WEST SUSSEX COUNTY COUNCIL CONSULTATION

TO:	Arun District Council FAO: Mr S Davis
FROM:	WSCC - Highways Authority
DATE:	19 May 2022
LOCATION:	Nyton House, Nyton Road, Westergate, PO20 3UL
SUBJECT:	AL/58/22/DOC Approval of details reserved by condition imposed under AL/42/19/PL relating to condition 3-Construction Method Statement.
DATE OF SITE VISIT:	n/a
RECOMMENDATION:	Advice
S106 CONTRIBUTION TOTAL:	n/a

16.5M ARTICULATED VEHICLE ENTERING THE SITE

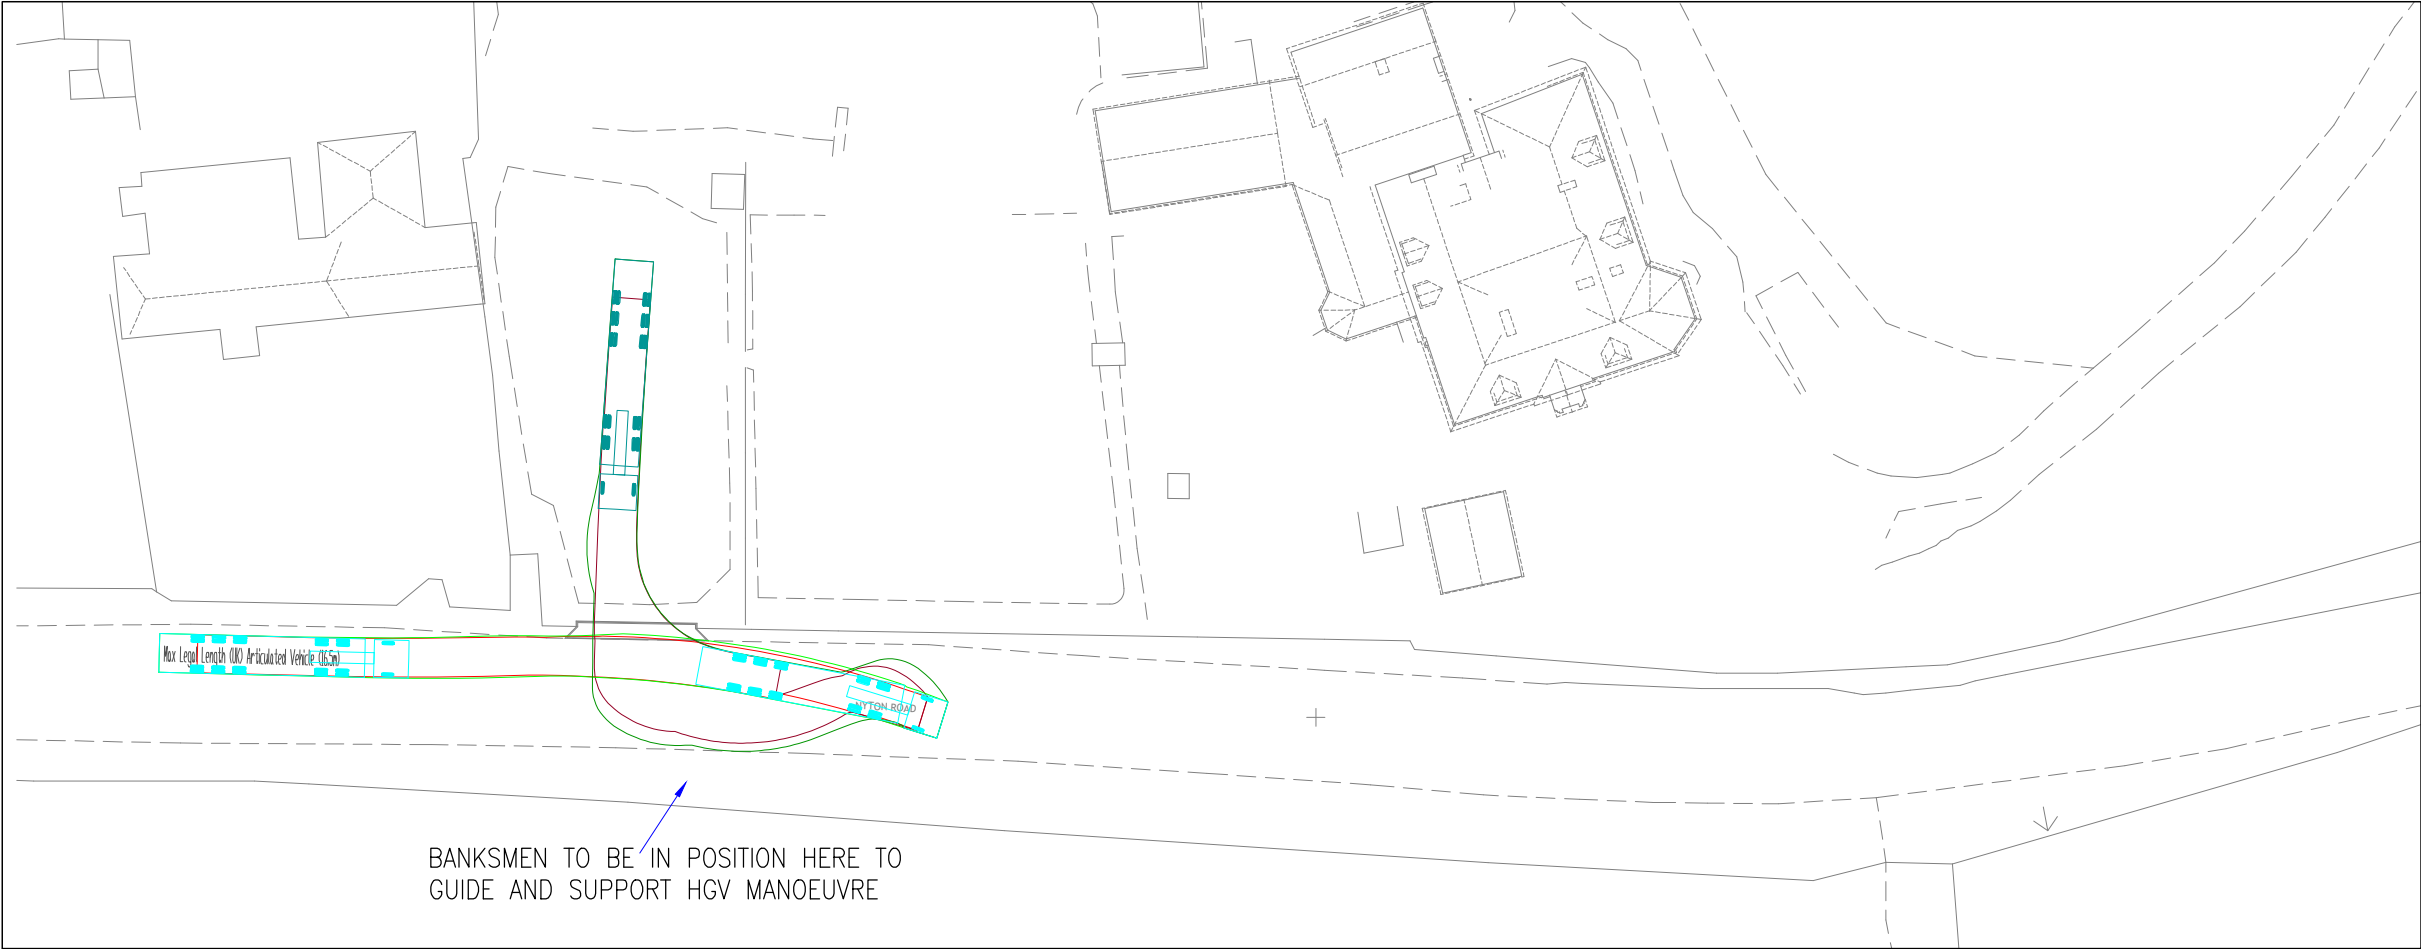
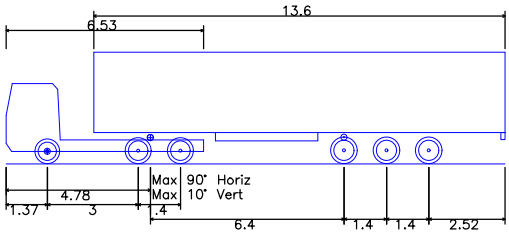
Swept path tracking plans demonstrate the geometry of the temporary access is suitable for the anticipated delivery vehicles (16.5m articulated vehicle and 12m rigid body vehicles). These plans are considered acceptable. The temporary construction access point must be implemented under licence to a temporary specification obtained from the WSCC Area Highways Manager.
